From: Sarah Burrow <Sarah.Burrow@arun.gov.uk>
Sent: 20 April 2021 17:12
To: Maria Tomalova <Maria.Tomalova@arun.gov.uk>
Cc: Planning.Responses <Planning.Responses@arun.gov.uk>
Subject: RE: Planning Consultation on: AL/31/21/DOC

Engineers Comments Regarding Surface Water Drainage

Application No: AL/31/21/DOC
Registered: 1st March 2021
Site Address: Land to South of Sundown Littleheath Road Aldingbourne BN18 0SR
Description of Works: Approval of details reserved by condition imposed under ref APP/C3810/W/19/3241407 (AL/62/19/PL) relating to Condition Nos 3 - surface water drainage and 4 - protection of retained trees & boundary vegetation.

Image of initial test taken on site within a 300 x 300 test hole at 800mm depth. This was adopted as the water filtered very quickly.

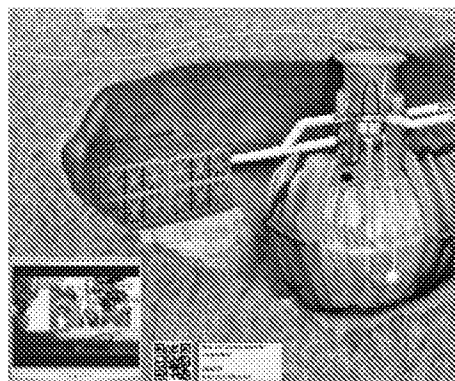
1. Please provide more detail regarding the infiltration testing completed on site. My initial impression is that;
 - a. The test was completed in an undersized pit (0.3m x 0.3m x depth, instead of min 0.3m x 1m x depth). Please confirm whether or not further tests have been undertaken in accordance with BRE365.

- b. The depth of the test (0.8mbgl) does not correspond with the depth of the proposed soakaway (1.3mbgl). Without being able to read the geological data it is not possible to assess the potential impact of this difference.

- c. Only one infiltration rate has been given and this is based on an approximate time with an infiltration rate based on experience/estimation. If three tests were completed please provide all results. Please provide appropriate calculations for the infiltration rate and use the worst case (not the average) for the design.

DRAWING TITLE
Proposed Site Plan
Storm Drainage

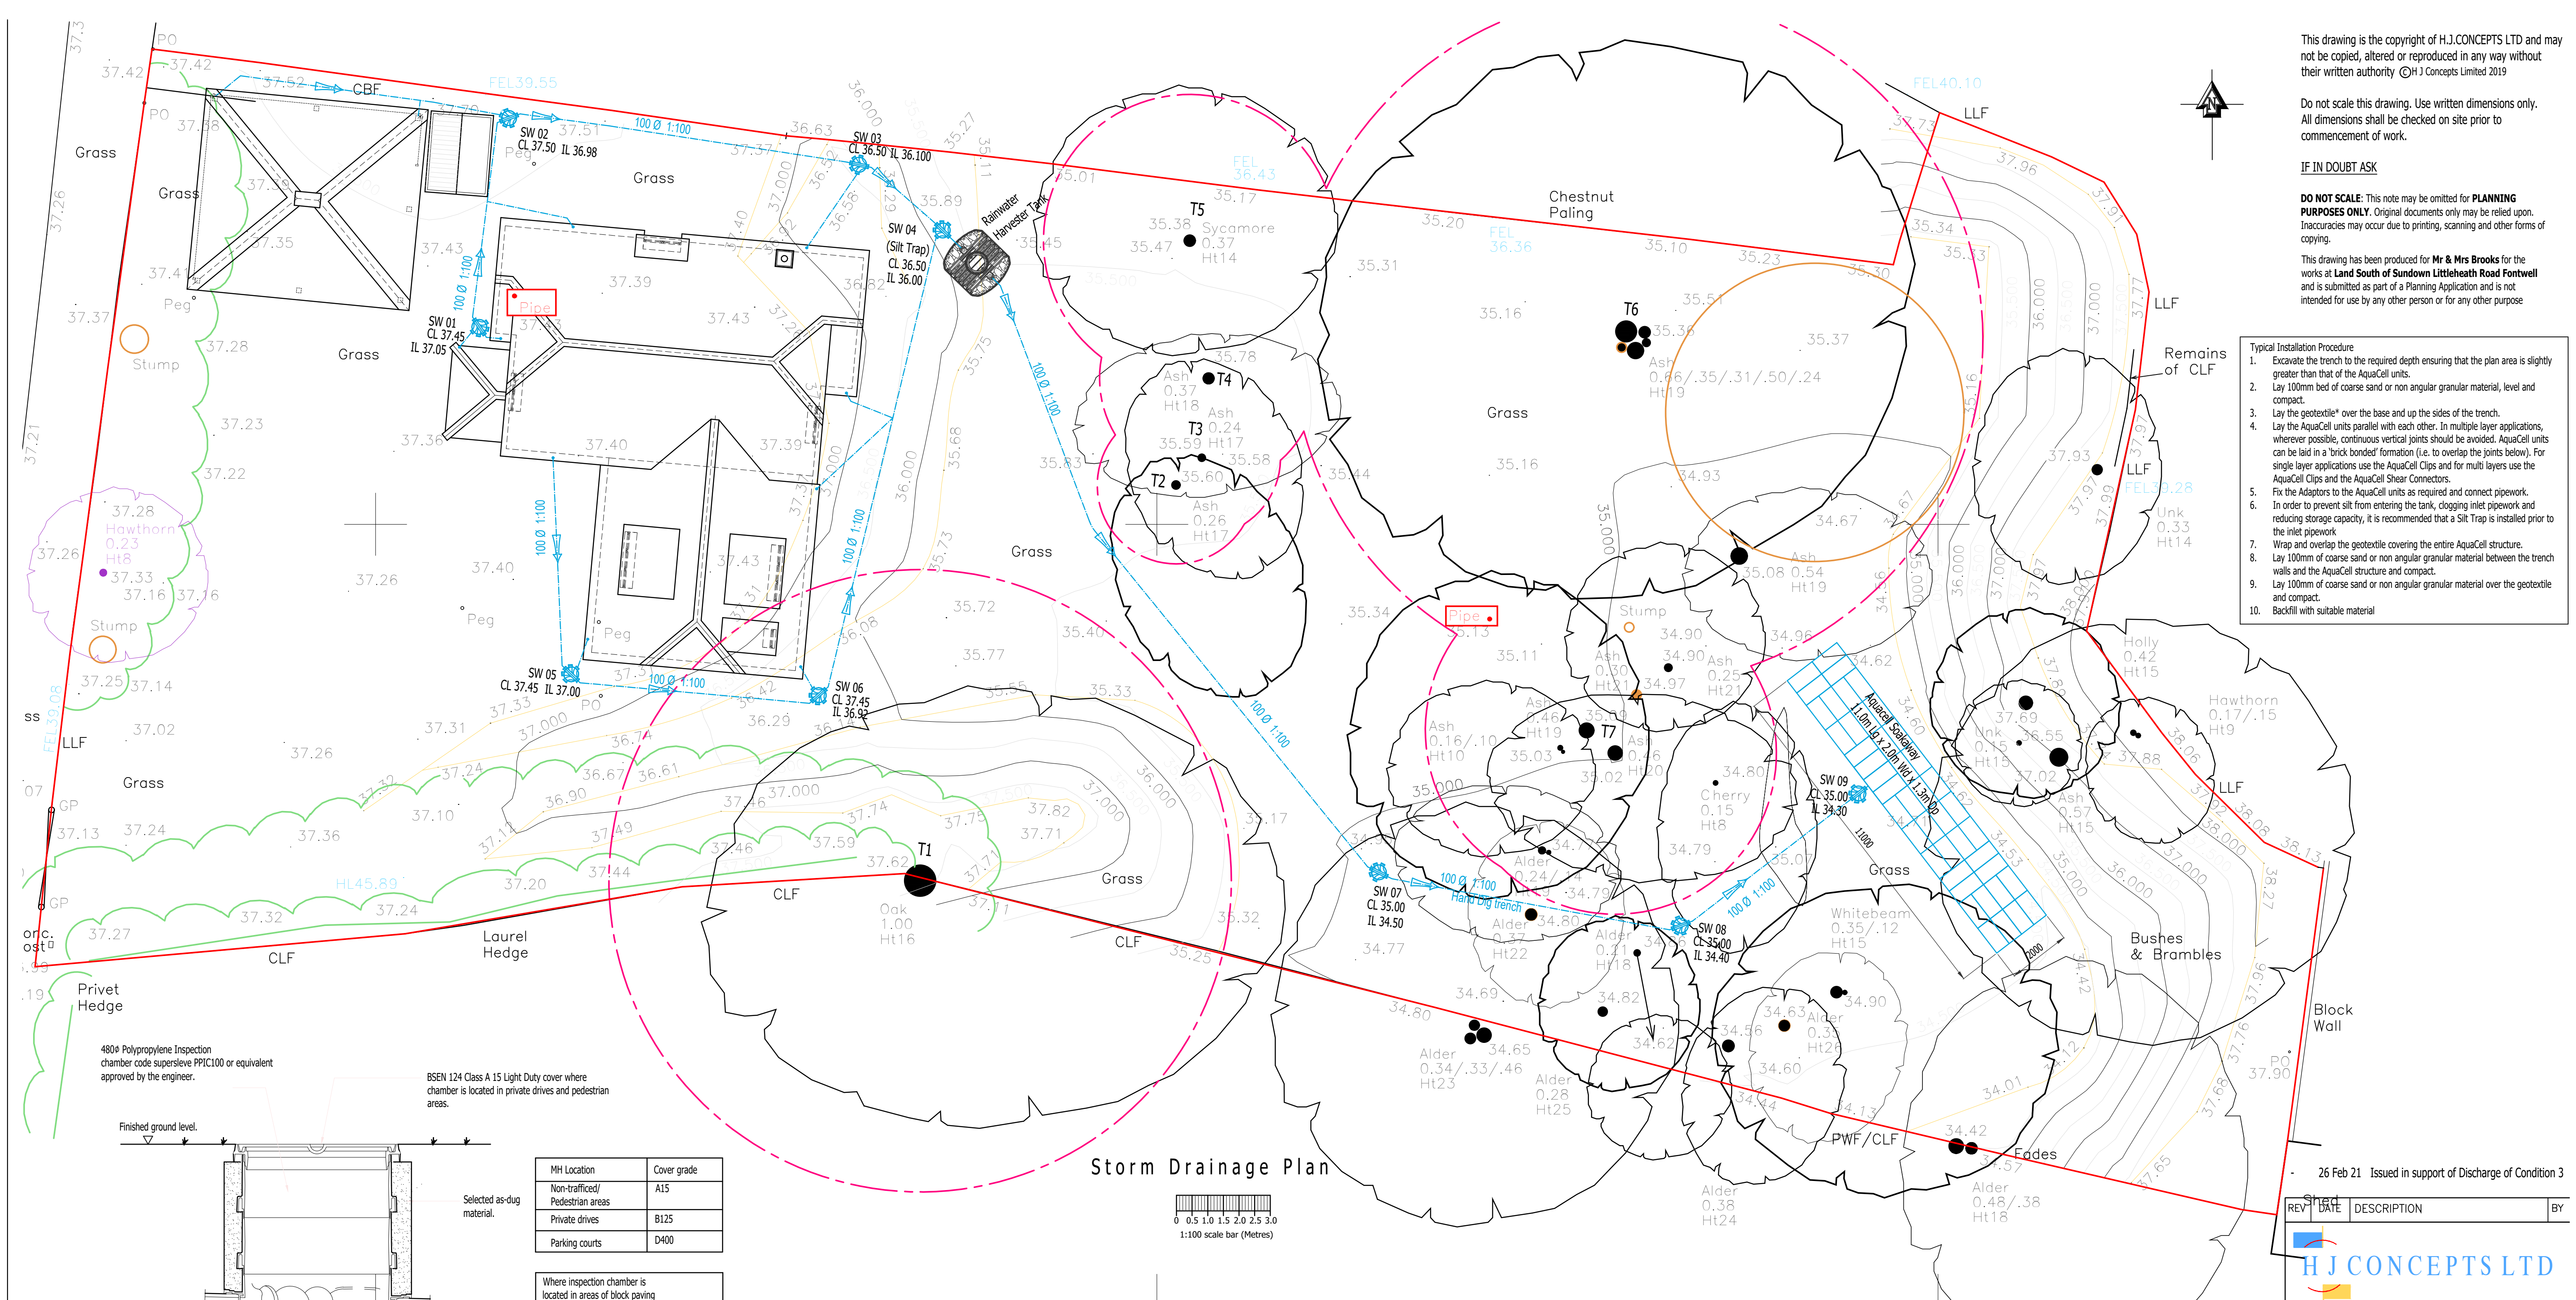
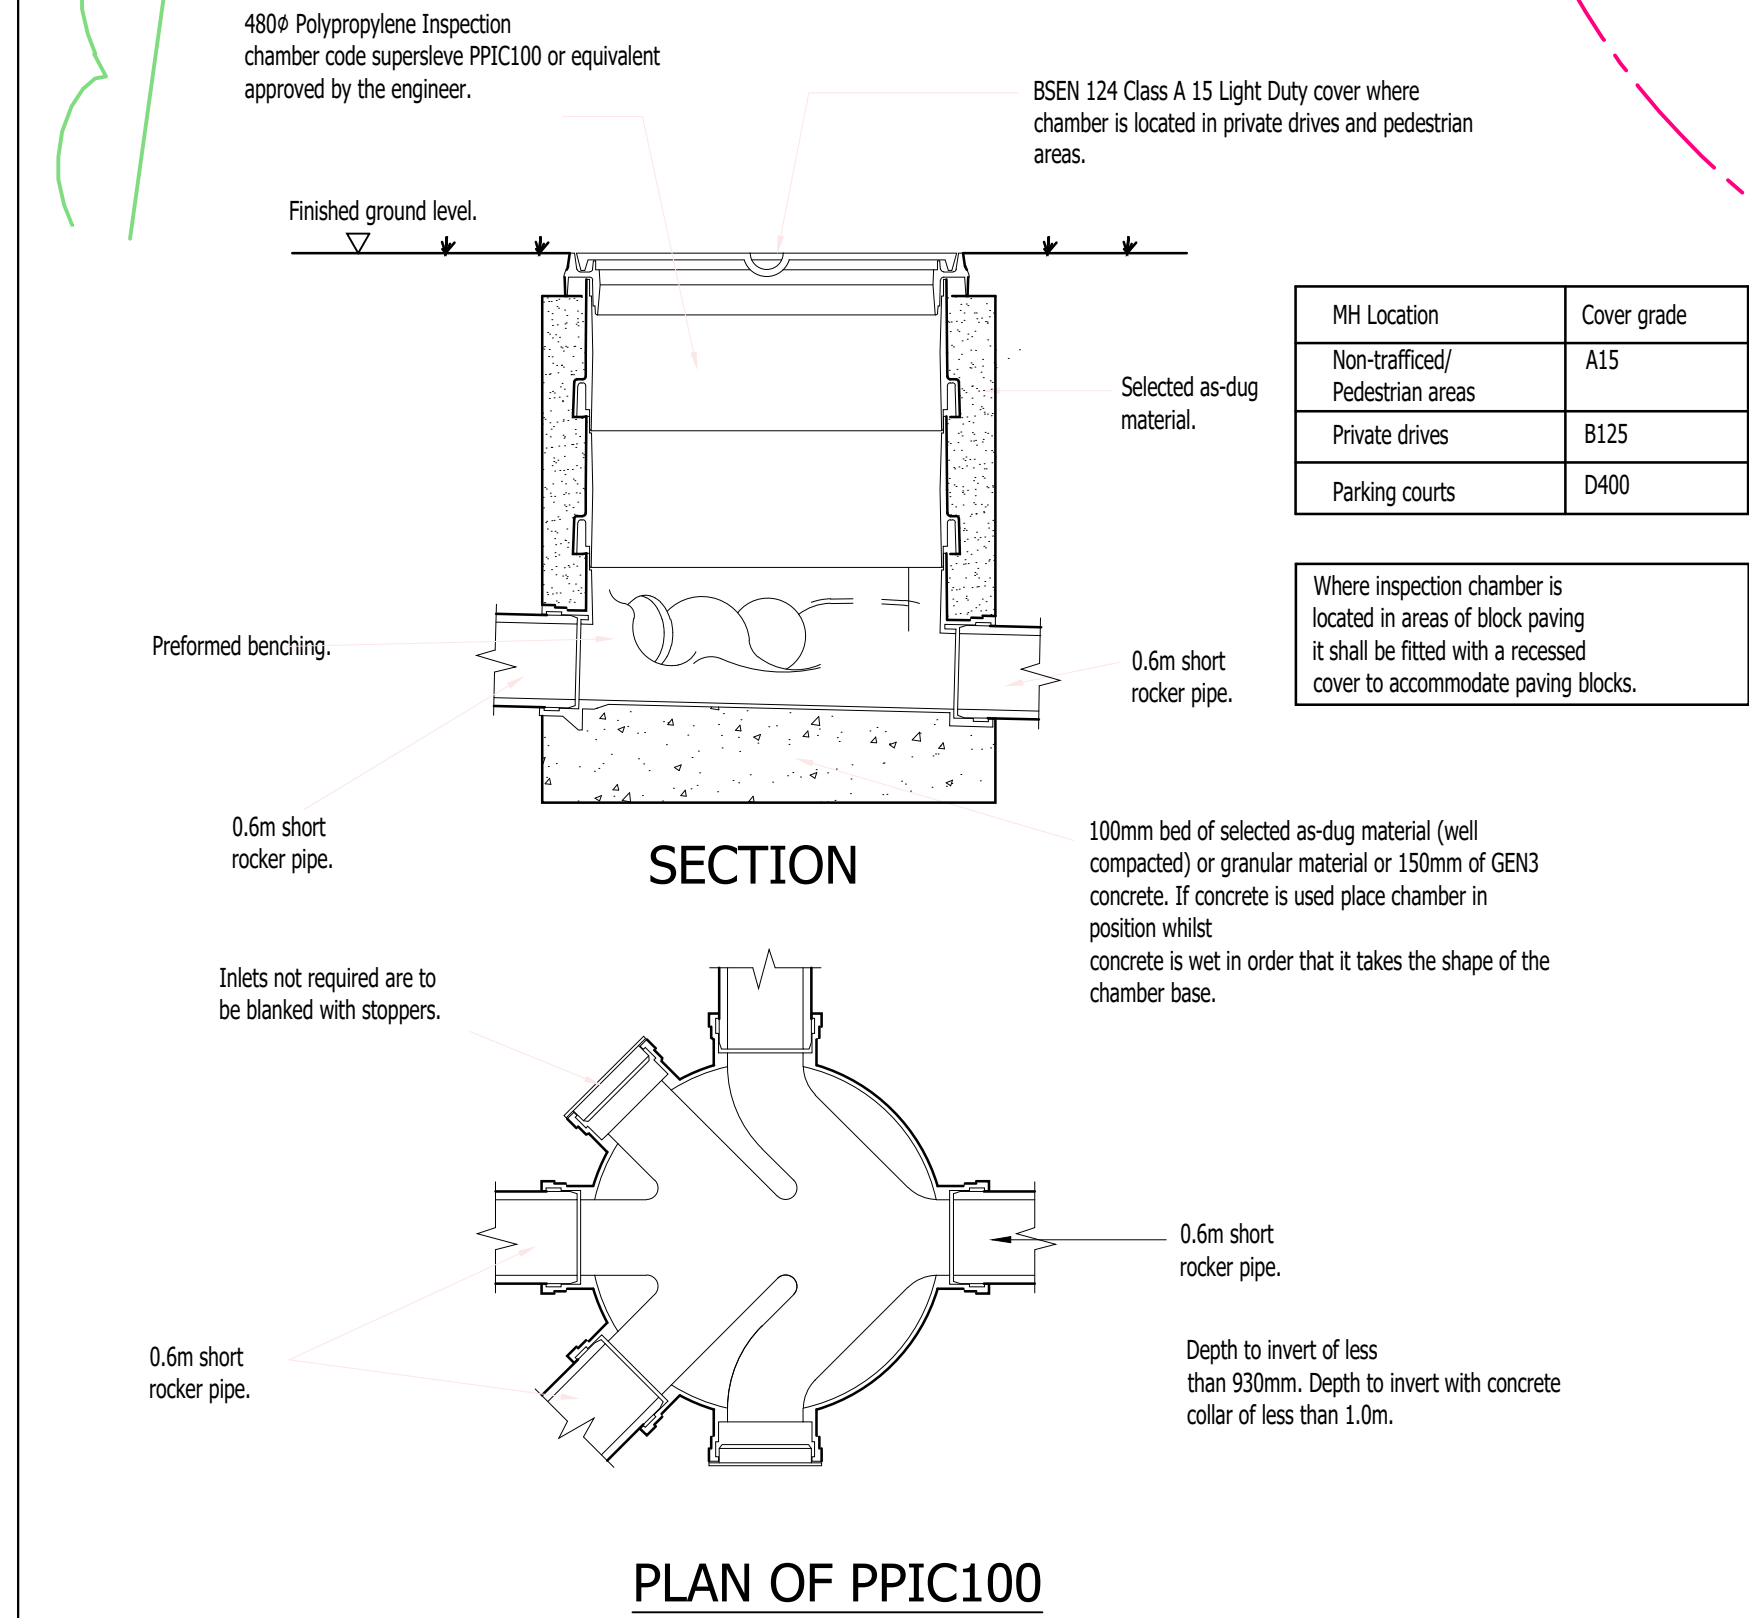
- d. No date has been provided for the infiltration testing – please confirm when infiltration testing was completed.
 - e. No location appears to be shown on Proposed Site Plan Storm Drainage Dwg 17-1197-DR501 for the infiltration tests or the groundwater monitoring points. Please add the locations to the drawing.

- b. It is not clear where the 40% allowance for climate change is being applied, this should be applied to the rainfall data.
3. Please provide an inspection chamber at the connection between SW06 and SW04 on the drainage layout.

Fig.4 – tree protection plan

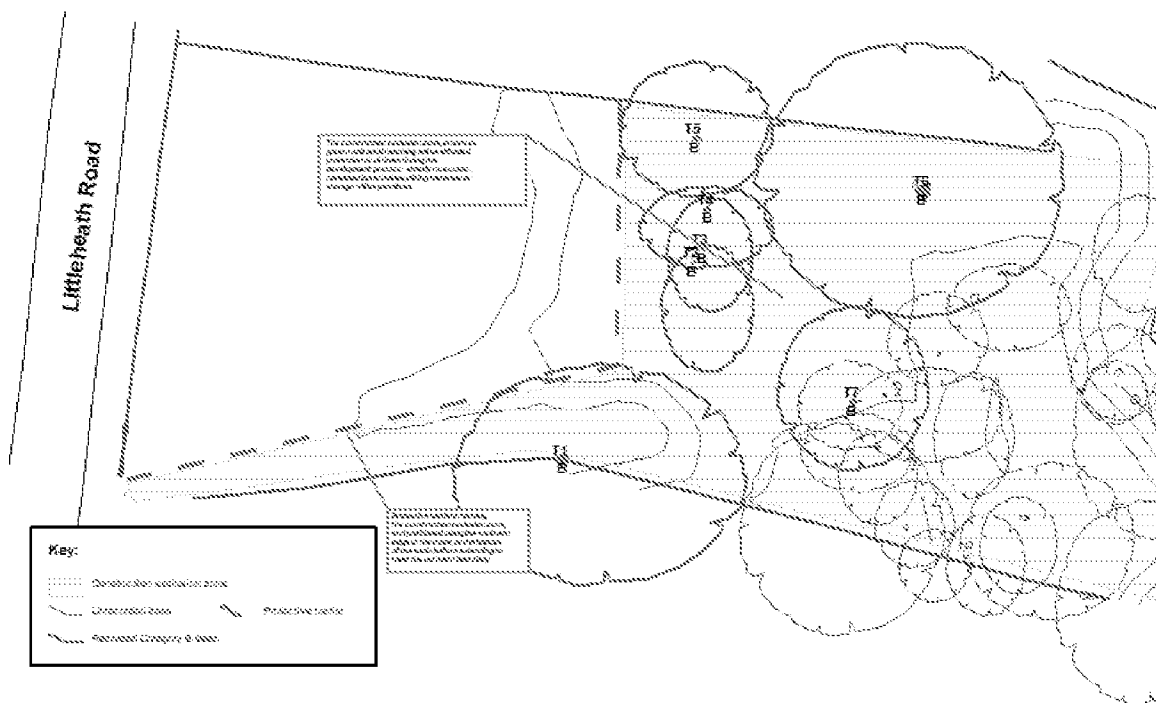
4. The arboricultural report states in paragraph 11.2 that a construction exclusion barrier will be in place for the protection of trees in the eastern part of the site. The area is to be "afforded protection at all times during development process; strictly no access, construction activities, mixing materials or storage will be allowed." Yet the surface water drainage design routes pipes through the area and sites a significant soakaway within the area. Furthermore, the Alder shown on the Drainage Layout appears to be being retained (as it is not located within the site), as such the roots of this tree should be considered in the drainage design. At present the surface water drainage design appears to be in direct conflict with the arboricultural report. Please ensure that the tree officer is aware of the conflict at the time of his consultation response.
